From: Sarah Burrow <Sarah.Burrow@arun.gov.uk>
Sent: 22 January 2021 16:43
To: Maria Tomalova <Maria.Tomalova@arun.gov.uk>
Cc: Planning.Responses <Planning.Responses@arun.gov.uk>; [REDACTED]
Subject: RE: Y/142/20/DOC

Engineers Comments Regarding Surface Water Drainage

At this stage it is not possible to recommend that conditions 10 or 11 imposed under Y/121/19/PL are discharged. I have the following comments that require addressing before I can recommend discharging the conditions:

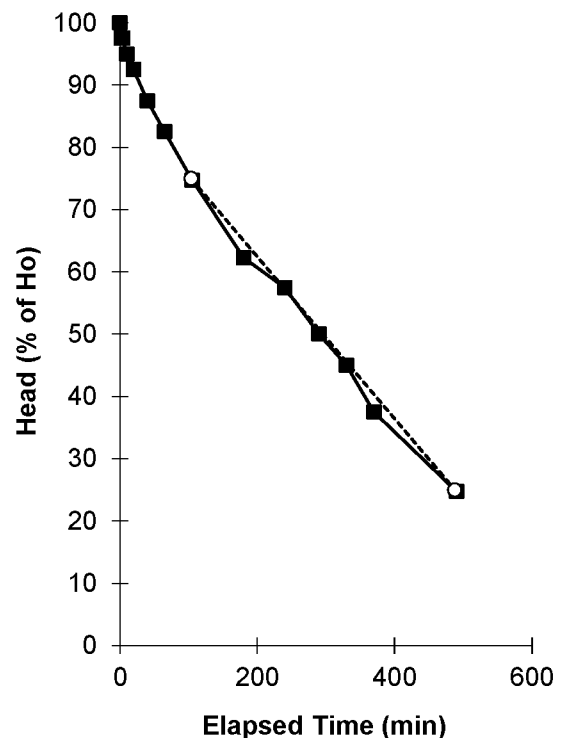
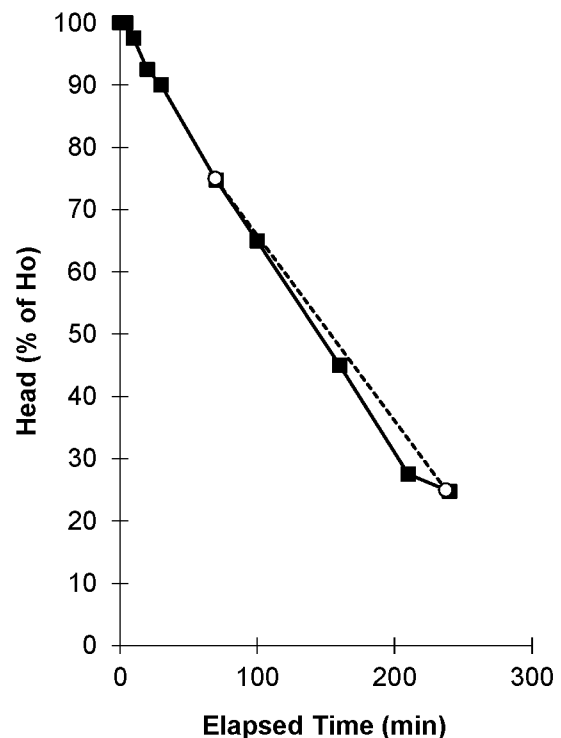
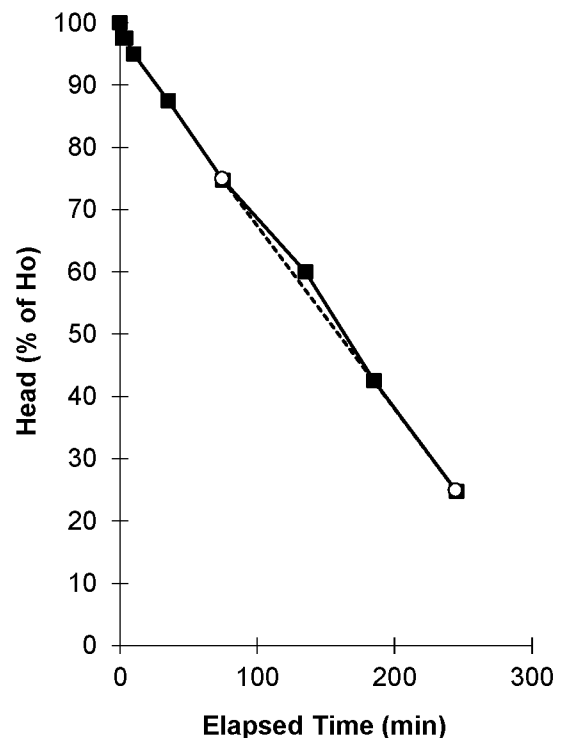
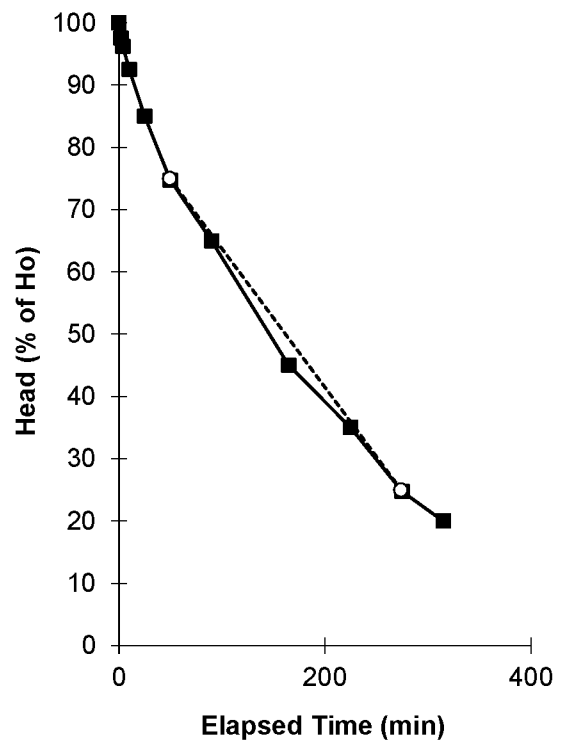
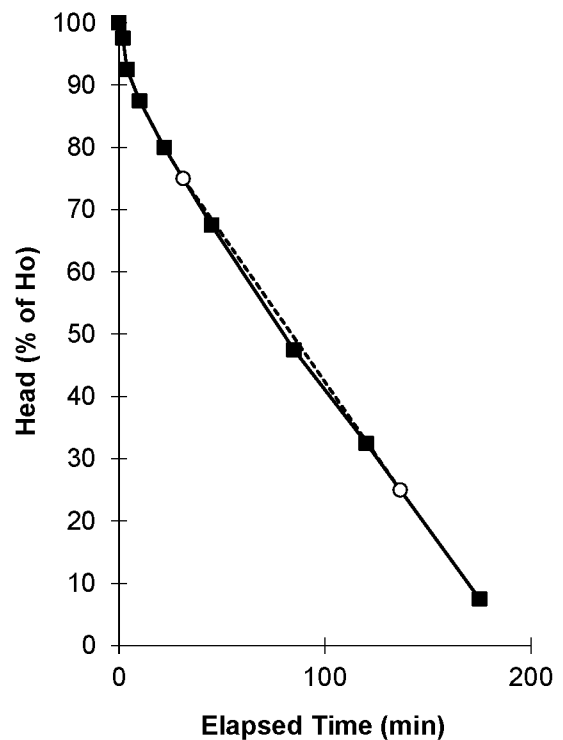
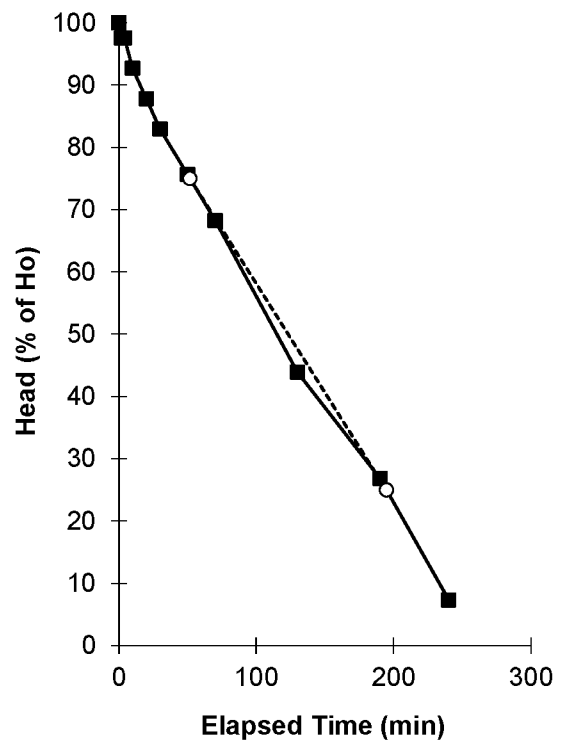
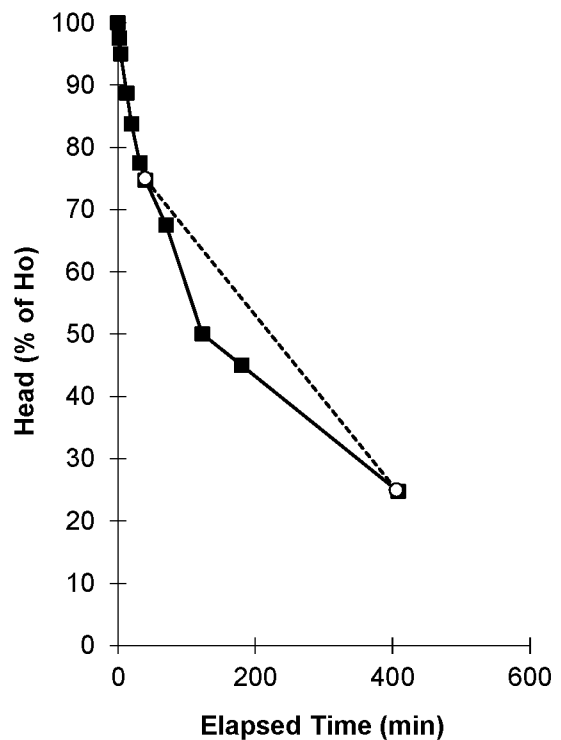
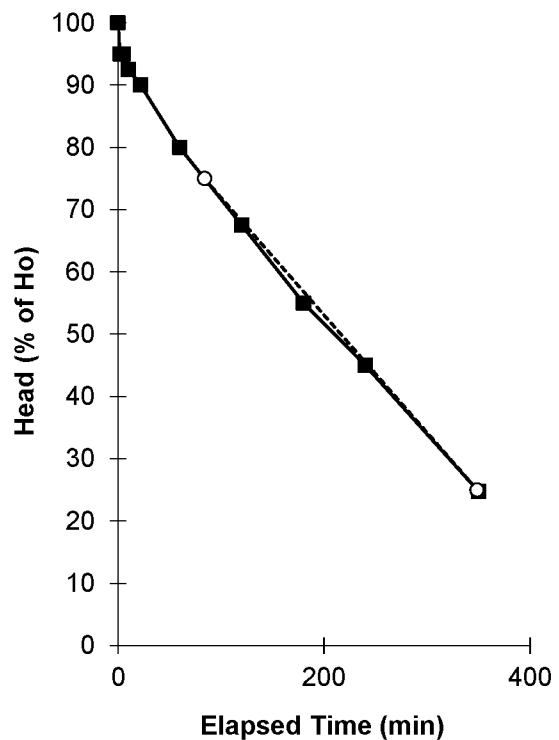
2. The infiltration testing that has been supplied was undertaken in autumn (early November). Again, it is a stipulation of the condition that this testing is undertaken in winter (defined by the met office as December to February inclusive). I would also like clarification regarding how the tests were completed, specifically with regards to the piping of the water to fill the pits, common practice would be to use a bowser or to empty a pre-filled receptacle into the pit to fill it quickly enough to accurately measure the infiltration rate, please elaborate on the method. It is also surprising and unexpected to see the infiltration rates improve over the course of the tests.

On the basis of the above, it is recommend that further infiltration testing is completed now, to capture the infiltration rate in the correct period. This needs to be repeated for all three test pit locations, please ensure that the testing is no deeper than 0.6mbgl, assuming groundwater is evidenced below this level.

Soakaway Test No. SA203 - Test 2
Contract: Yapton
Contract No. J20-043

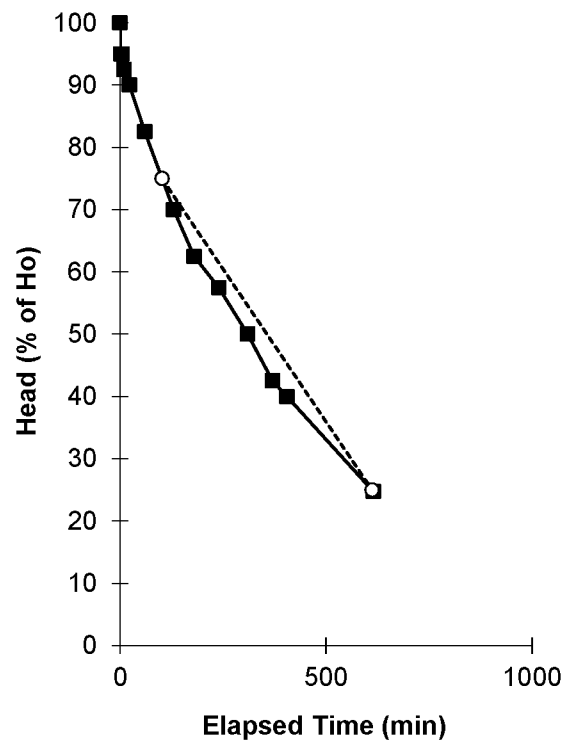
3. The calculations do not use the slowest infiltration rate for the site of 2.97×10^{-6} m/s (SA203). These will need to be adjusted irrespective of the outcome of points 2 and 3.
